Our ref: WA/2021/129106/03-L01
Your ref: 21/01630/OUT
Date: 24 January 2022

Outline planning application for residential development (within use class C3), open space provision, access, drainage and all associated works and operations including but not limited to demolition, earthworks, and engineering operations, with the details of appearance, landscaping, layout and scale reserved for later determination

Land at North West Bicester, Home Farm, Lower Farm and SGR2, Caversfield

DRAWING TITLE: CLIMATE CHANGE FLOOD MAP

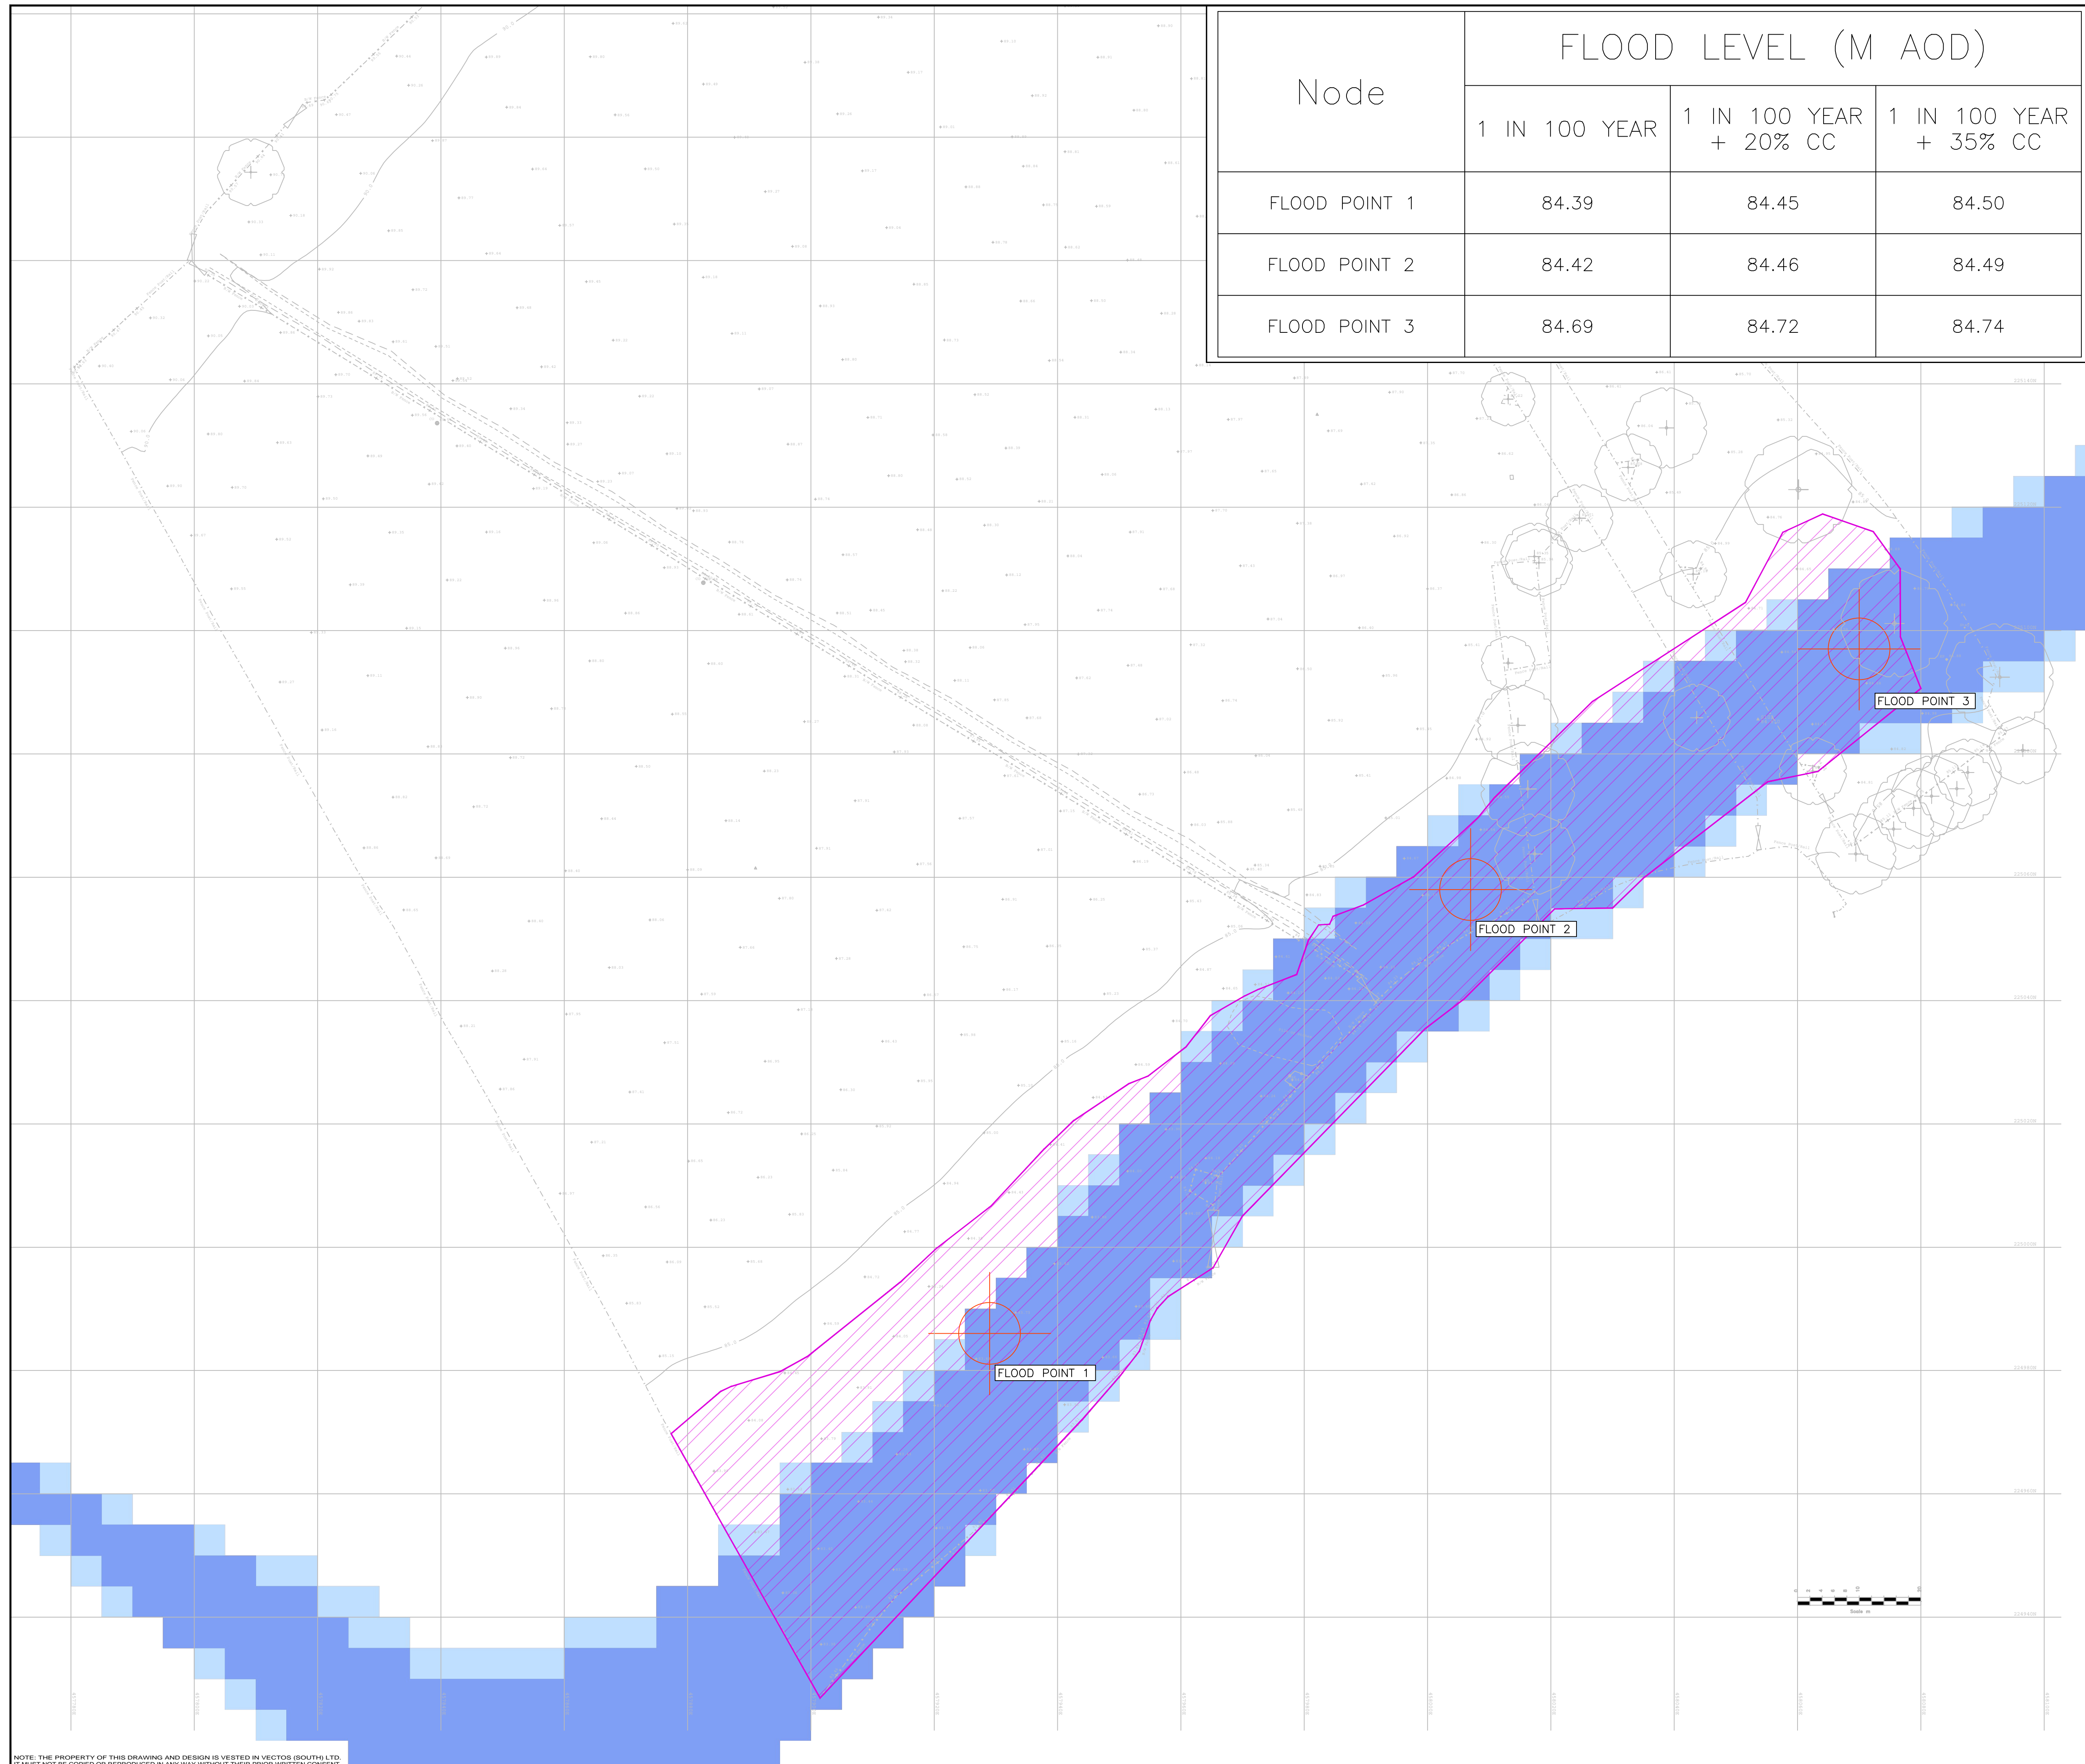
The Flood Risk Assessment (FRA) details the hydraulic modelling of the two local watercourses in order to better define the flood zones. Our review of the hydraulic model and associated hydrology has highlighted several issues that need addressing before the results can be accepted. These issues are set out in the attached Environment Agency model review response which has been copied to the applicant for their consideration and the required actions will be need to be undertaken.

Please note that the FRA will need to be updated and potentially revised once the model has been signed off as being a suitable evidence base, and our objection will remain until this has been done. This is necessary to ensure the correct extent of flooding affecting the site is established and the reserved matters application will ensure that no development is located within the accepted flood risk areas both now and in the future due to climate change, in line with the principals of the FRA.

In addition, the FRA advises that finished floor levels of all properties are set at least 150mm above existing ground level. While this should be sufficient if no development is proposed within areas of flood risk, we would advise as a precaution against any unpredicted flooding, finished floor levels of properties should be at least 300mm above the appropriate climate change flood level.

To overcome our objection, the applicant should submit revised evidence which addresses the points highlighted above and within the attached Environment Agency model review response.
